# CONSTRUCTION PLANS FOR TOWNHOMES AT WESTERN

LOT 1, CIMARRON SOUTHEAST FILING NO. 2C, SOUTHEAST QUARTER SECTION 7, TOWNSHIP 14 SOUTH, RANGE 66 WEST OF THE 6TH P. M.,  
EL PASO COUNTY, COLORADO

## CONSTRUCTION PLANS COVER SHEET

PCD File #: PPR-24-15

C2.2 MVE PROJECT 61203  
MVE DRAWING CON-CD

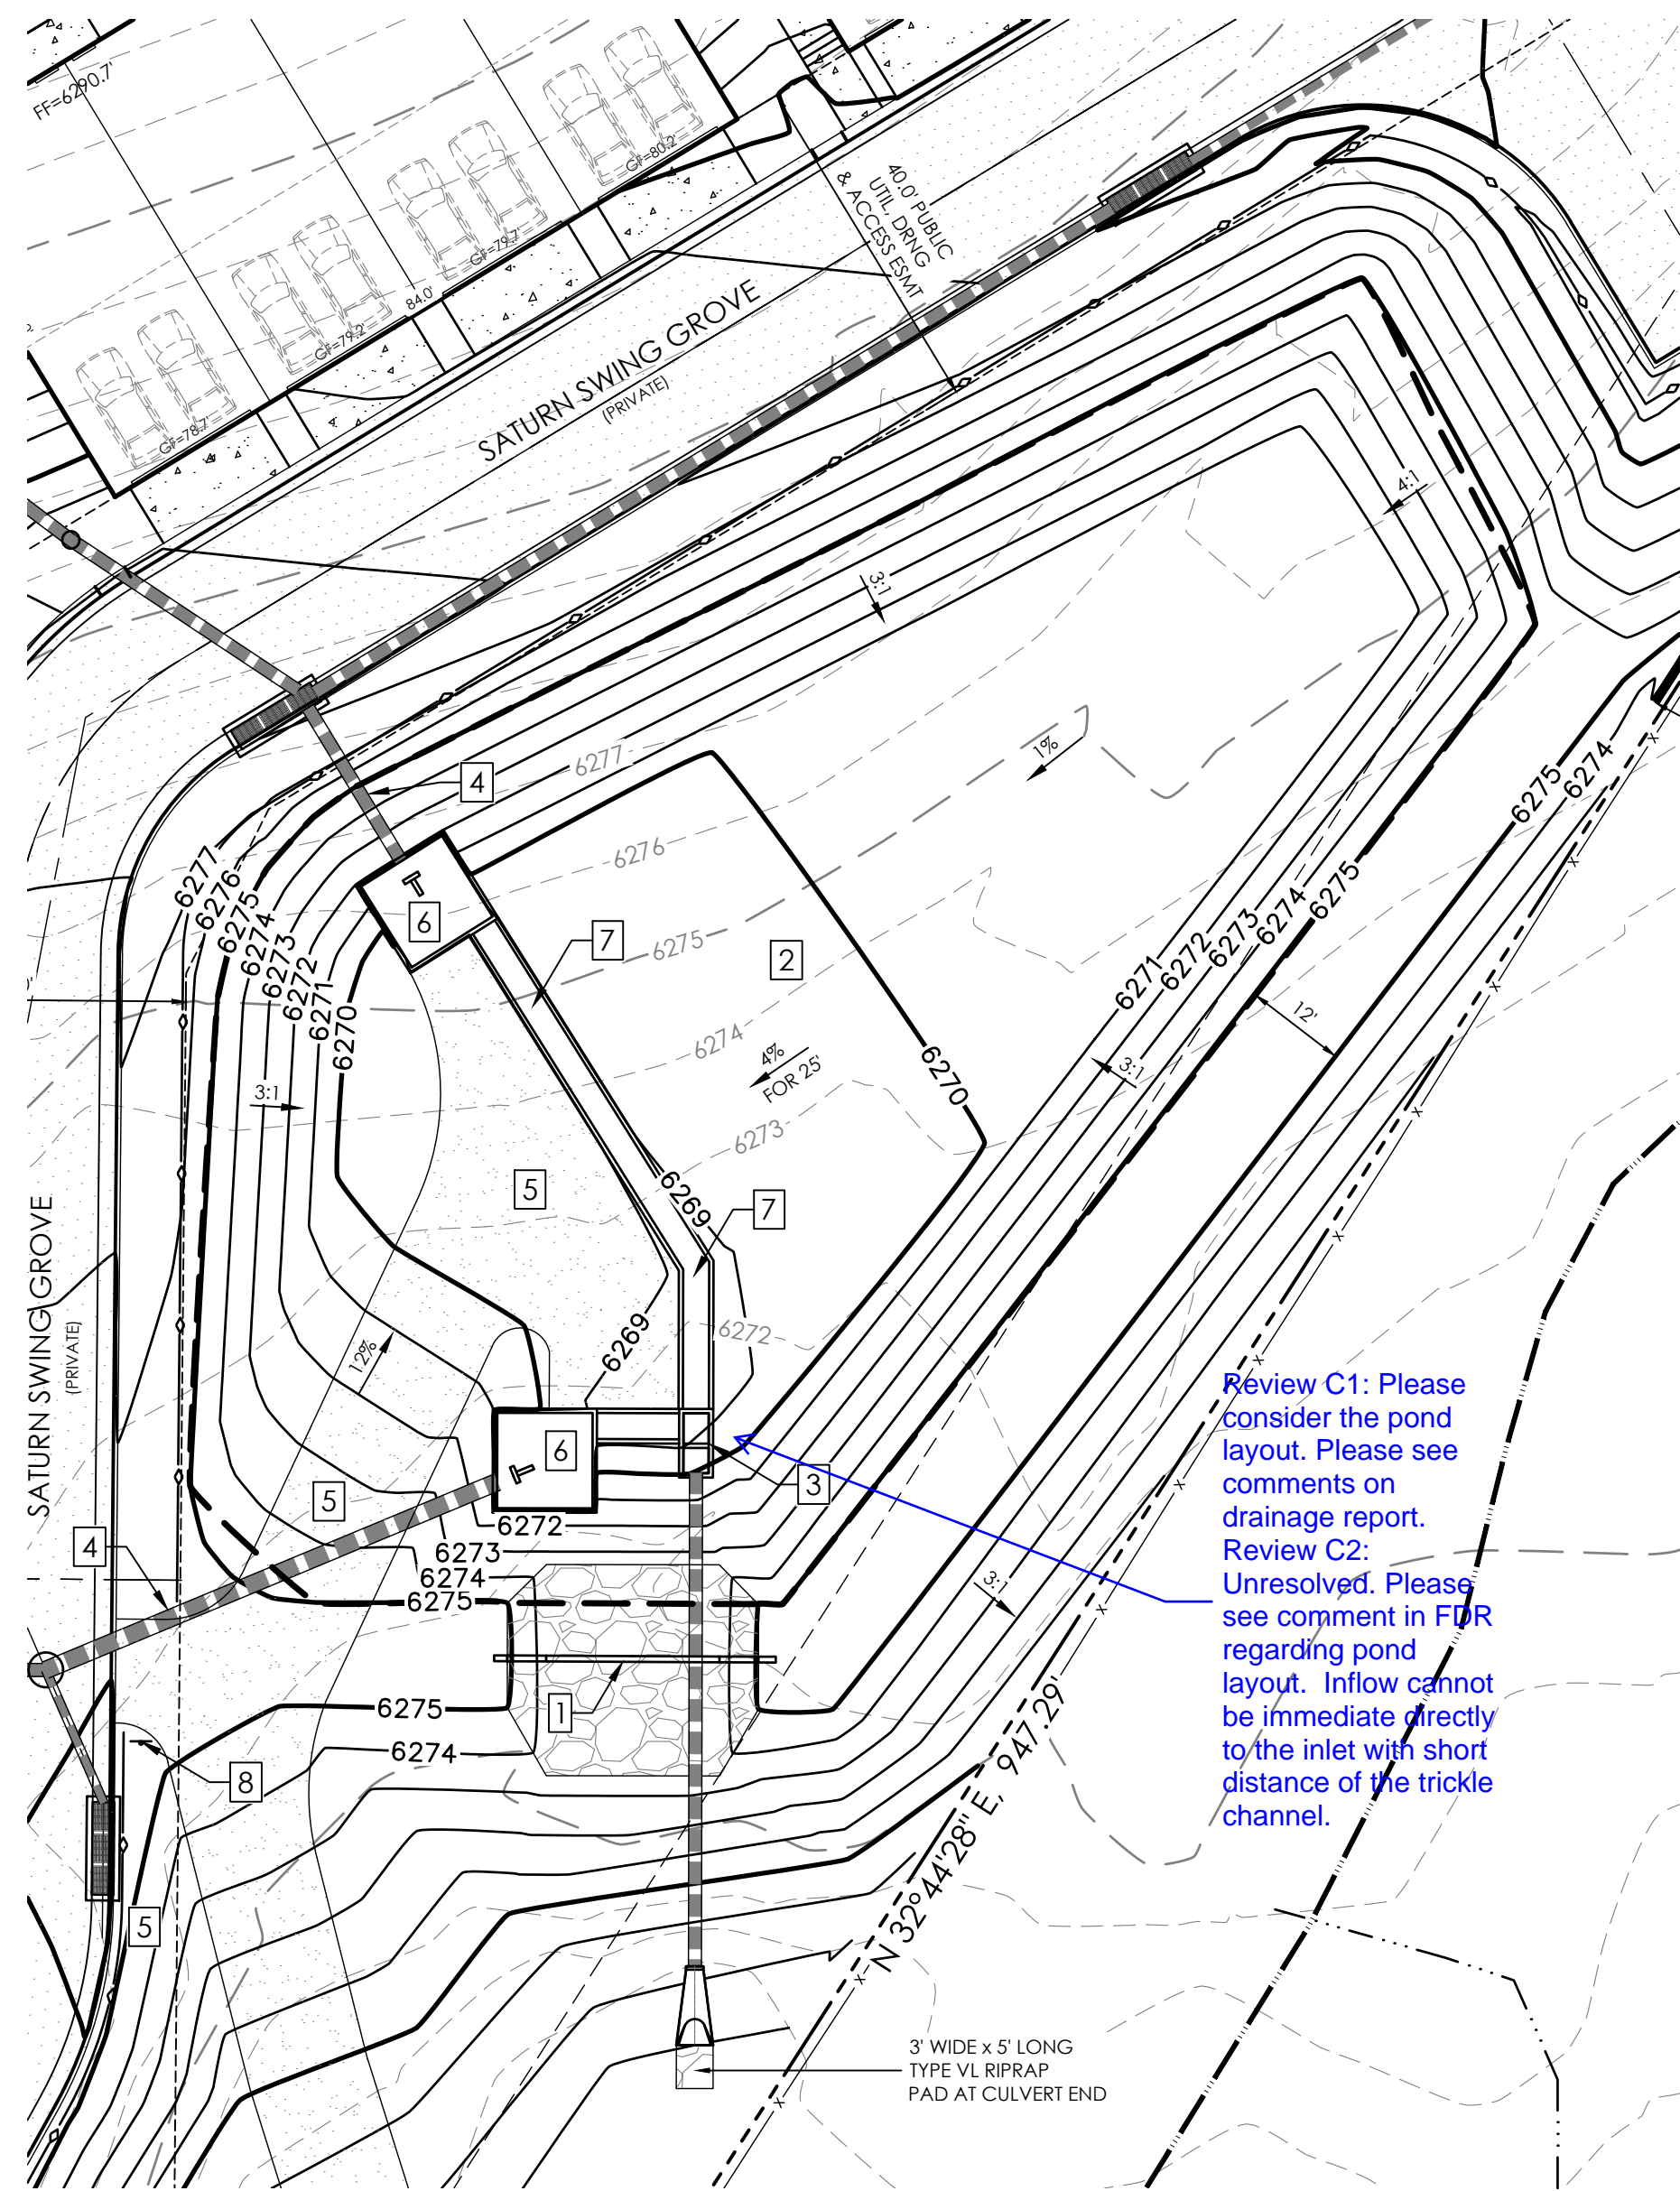
Please show the whole Detention pond, and side slopes of the pond. Note that side slopes is no steeper than 3:1.

Please show and label embankment width

Note: it has been observed that grade breaks on either side of access ramps are common points of erosion during construction. Consider designing a ditch on either side of the ramp and/or show applicable temporary BMPs that will help prevent erosion.

Pond bottom should have a minimum slope of 3% to the trickle channel and micropool (USDCM Vol 3, detail T-5). Please adjust to minimize future maintenance needs.

Please show and label slope of the bottom of the pond.

Recommend capping the top of this opening to prevent debris from getting in between microscreen and orifice plate.

Please revise WSEL of 100yr-6271.6ft, EURV-6270.71ft and WQCV-6269.37ft to match the FDR calculations.

Per PDF pg 80 of FDR, this should be 6271.00. Revise to remove discrepancy.

Emergency Overflow is 6273.9ft. Please revise

Per PDF pg 80 of FDR, this should be 6267.67. Revise to remove discrepancy.

Assign a name/number to all PBMPs and then update all submitted text and drawings accordingly with consistent labeling throughout (example: "Pond A" or "Pond 1").

Diamond plate trash racks are not an equivalent replacement to those in our criteria. We have concerns that the diamond plate is going to be a constant maintenance issue with clogging. Diamonds plates may have the same percent open area as those shown in our criteria but this isn't the only criteria that decides equivalency with the ones specified in our criteria. The well screen and bar grates in our criteria are designed to be maintenance friendly whereas the diamond plate will clog more often.

Include callout for pet waste station(s) around the pond, with signage stating that pet waste must be picked up.

Please consider the pond layout. Please see comments on drainage report.

Pond bottom should have a minimum slope of 3% to the trickle channel and micropool (USDCM Vol 3, detail T-5). Please adjust to minimize future maintenance needs.

Consider future maintenance challenges of a 36in wide trickle channel. The most commonly available walk-behind Skid Steers have buckets that are 36in and wider. So it might only be possible to remove sediment from the ~63ft long trickle channel via hand tools, which is a significant maintenance effort. Just a common note we have received from many pond end-users who wish their trickle channel was wider.

Show cross slope at a min of 2%.
